# OBJECTION TO STATE SIGNIFICANT DEVELOPMENT APPLICATION

## Waterloo South Concept SSDA — SSD-93222706

Owners Corporation SP36476 — 110 Wellington Street, Waterloo NSW 2017

| <b>Date</b>           | 29 May 2026   |

Figure 1824: Carpark locations and entries

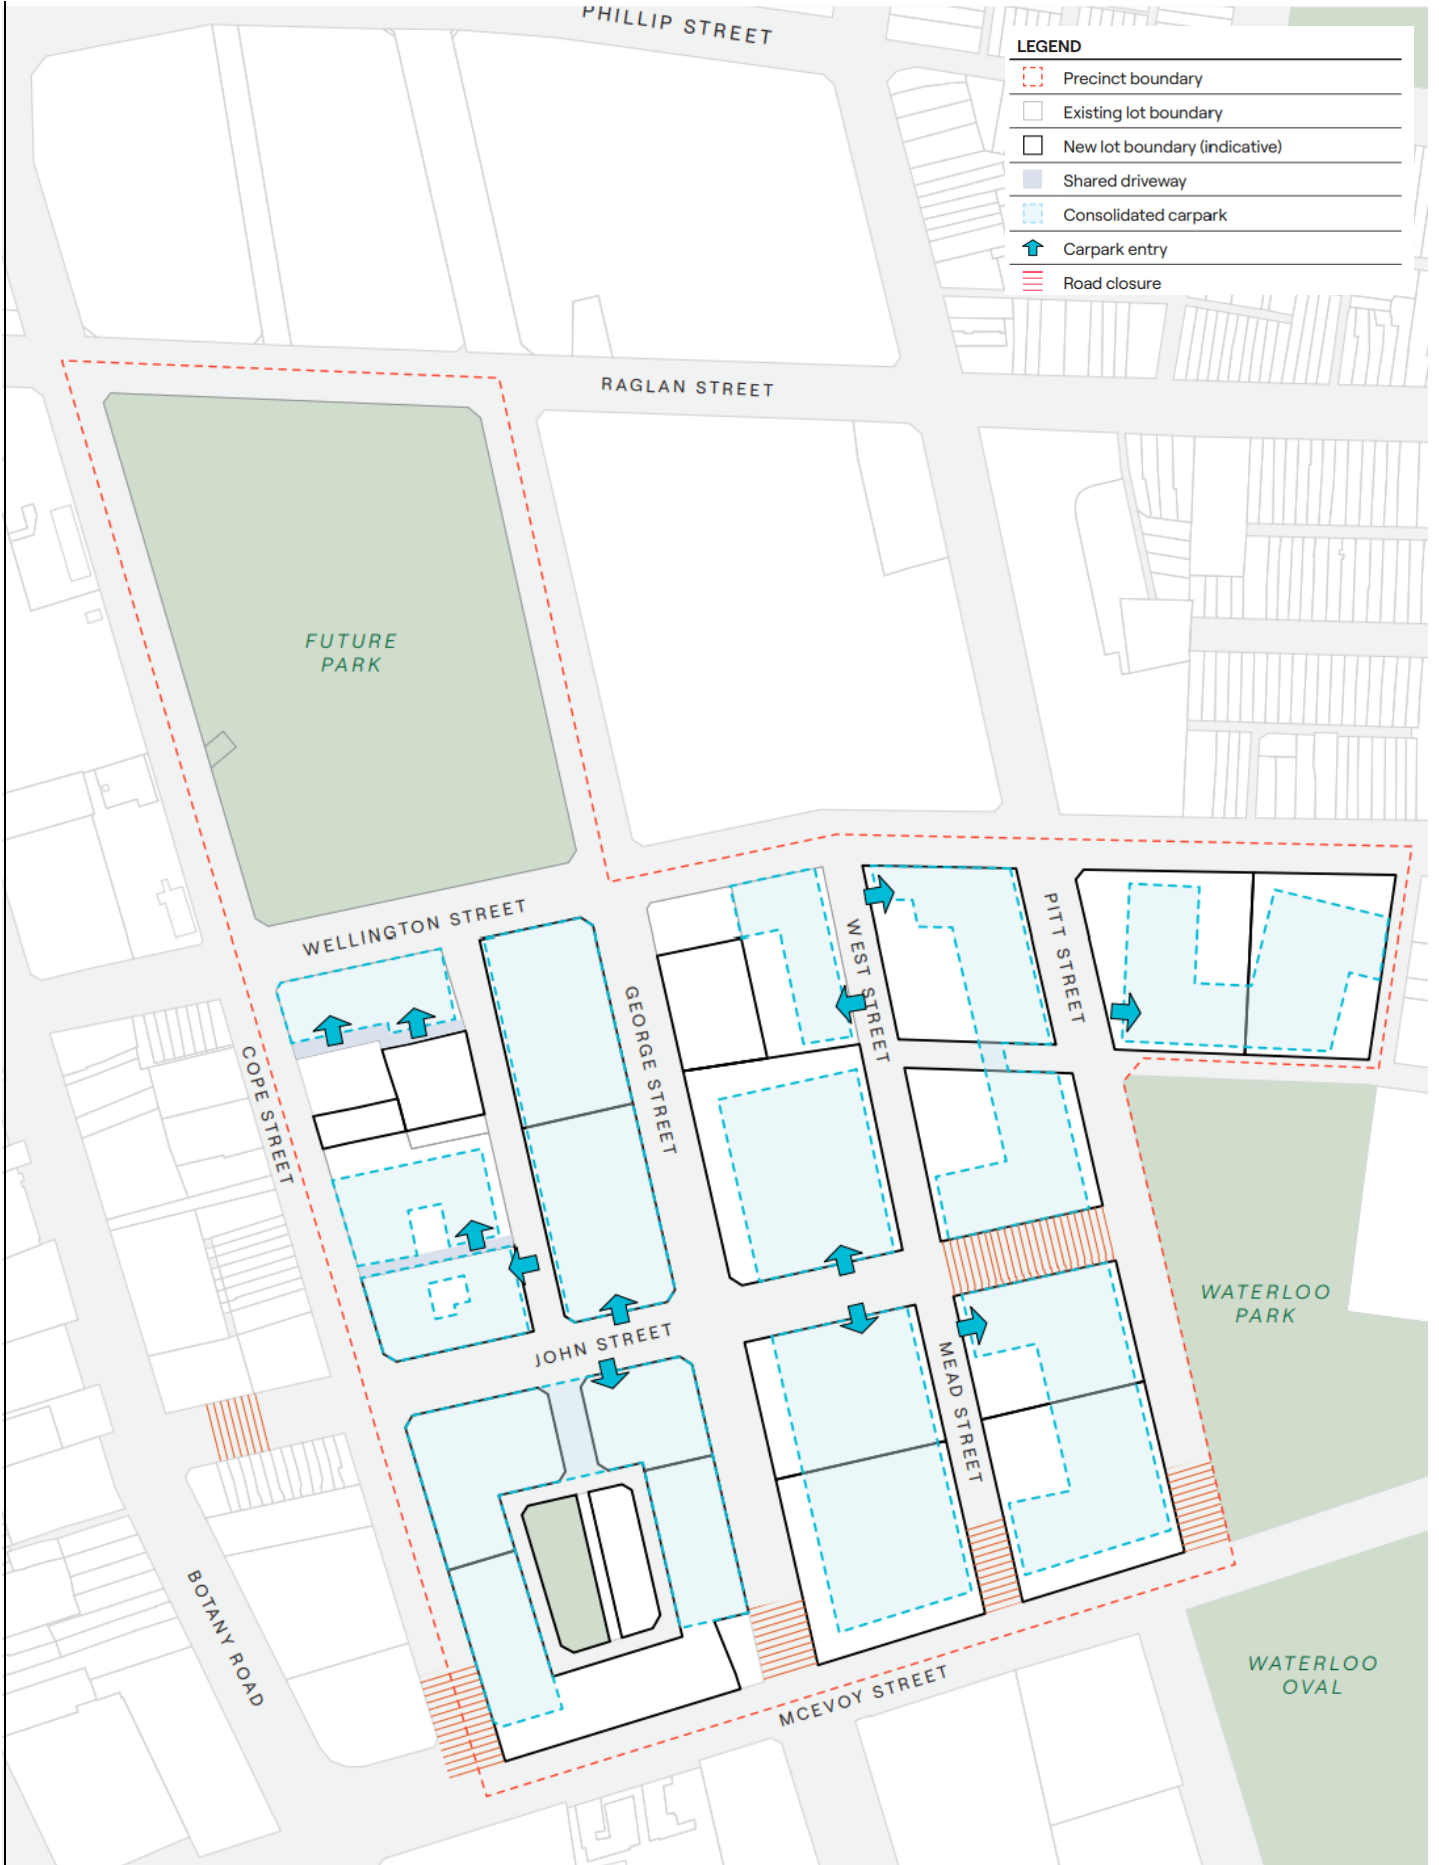
Figure 49 of the EIS (Indicative car park entrances, Updated Waterloo South Design Guide, SJB) identifies multiple carpark entries on West Street, serving Blocks 5 and 6. The EIS also confirms that Block 6's basement is accessed via Block 5, implying consolidated vehicle movements from multiple residential buildings onto West Street. The Design Guide cross-section for West Street (Figure 8(e)) confirms the street is proposed at 14m total width with a 3m travel lane — a width entirely incompatible with the volume and frequency of vehicle movements that will be generated by the carpark entries for two major residential blocks (Blocks 5 and 6) combined with the existing shared-zone pedestrian and cyclist use.

The residents and visitors of 110 Wellington Street use West Street as a primary pedestrian and cyclist access route, and as the principal entrances for residents when moving furniture in, or out of 110 Wellington as it is the only direct access to open common space area at 110 Wellington. The proposed carpark entries will

introduce 24-hour vehicle movements — including heavy construction vehicles during the 10–15 year construction programme — onto a street that is currently characterised by quiet shared pedestrian and cyclist activity. No specific pedestrian safety or traffic impact assessment has been conducted for West Street in the context of its use by residents of the privately owned buildings on its boundary.

- **West Street pedestrian safety assessment:** Require a specific pedestrian safety and traffic impact assessment for West Street addressing the conflict between proposed carpark entries for Blocks 5 and 6 and the existing shared pedestrian/cyclist zone, including during construction
